SOUTH HUMBER BANK ENERGY CENTRE PROJECT - APPLICATION FOR AN ENERGY FROM WASTE POWER STATION AND ASSOCIATED DEVELOPMENT - LAND AT THE SOUTH HUMBER BANK POWER STATION SITE, SOUTH MARSH ROAD, STALLINGBOROUGH, DN41 8BZ

THE PLANNING ACT 2008 – SECTIONS 51, 56 & 58

The Section 51 advice is reproduced in italics below along with the Applicant's responses.

TITLE: SOUTH HUMBER BANK ENERGY CENTRE ORDER LAND PLAN

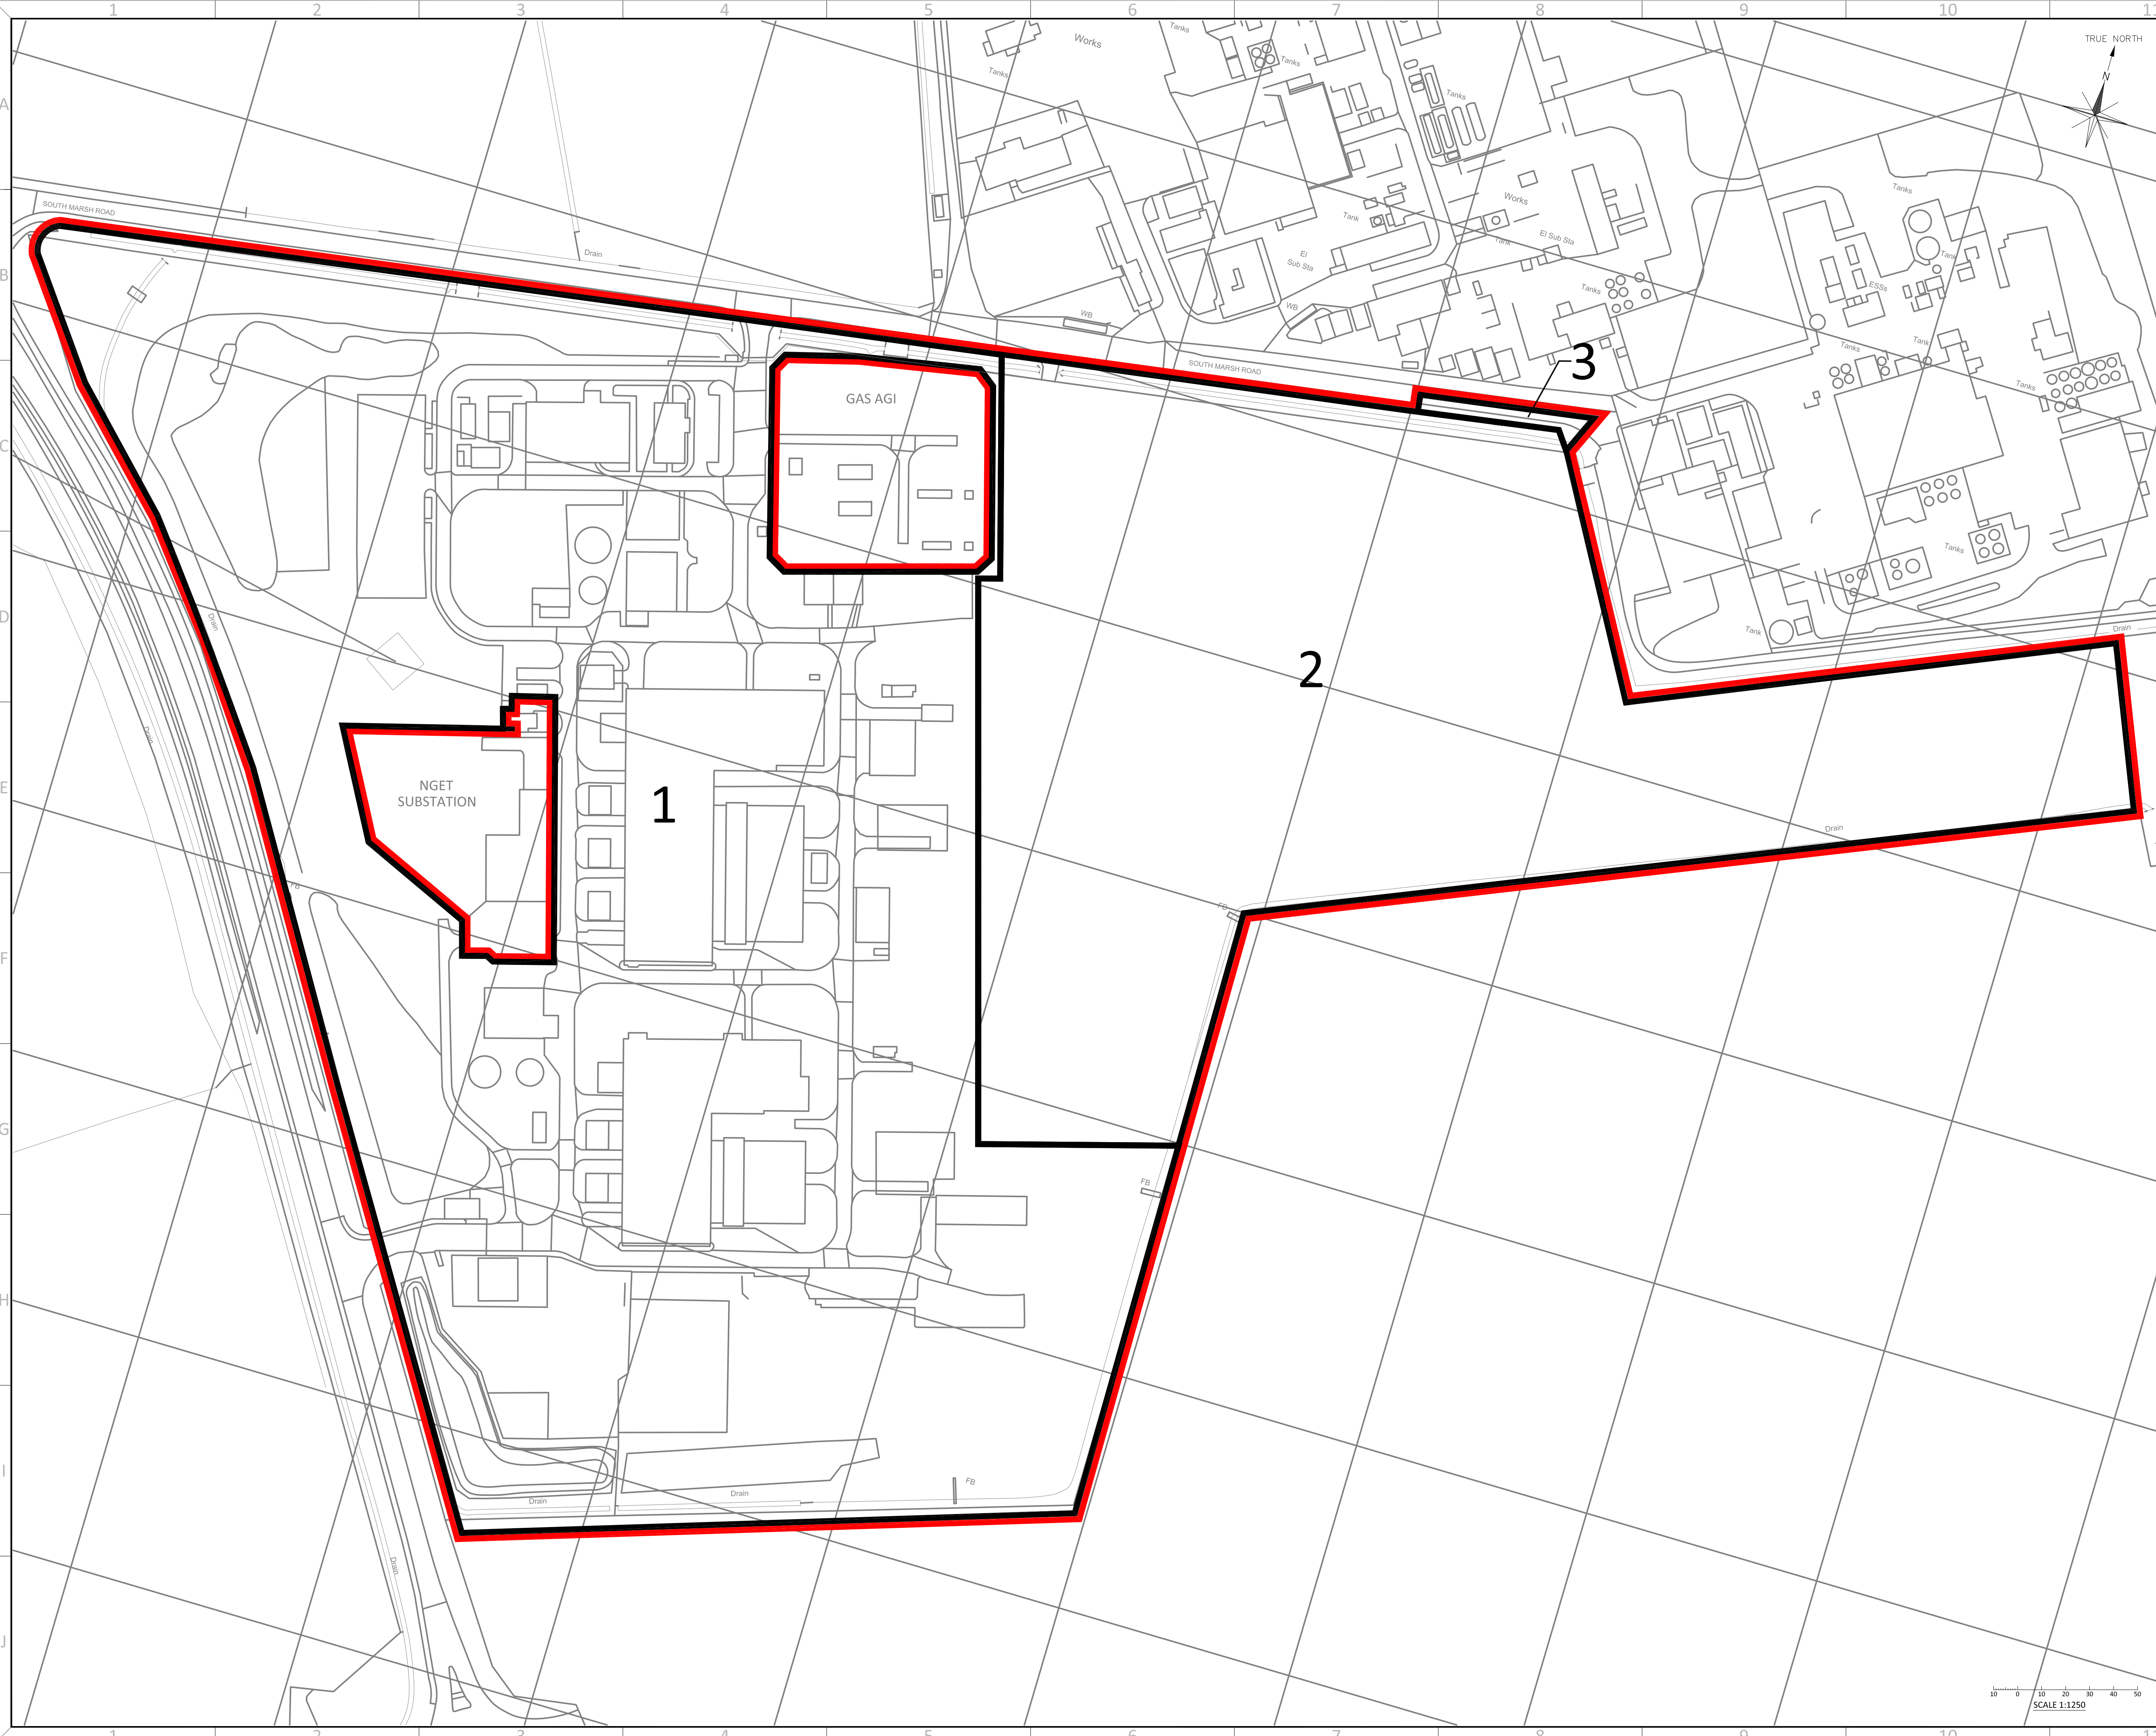
It would be helpful, to assist the examination, if the black line denoting Plot 1 could be drawn to exclude the AGI and substation, which are not within the Order Limits.

This has been redrawn and is enclosed (Document Ref. 4.2, rev 2.0). We request that the Examining Authority exercise discretion to accept this into the examination.
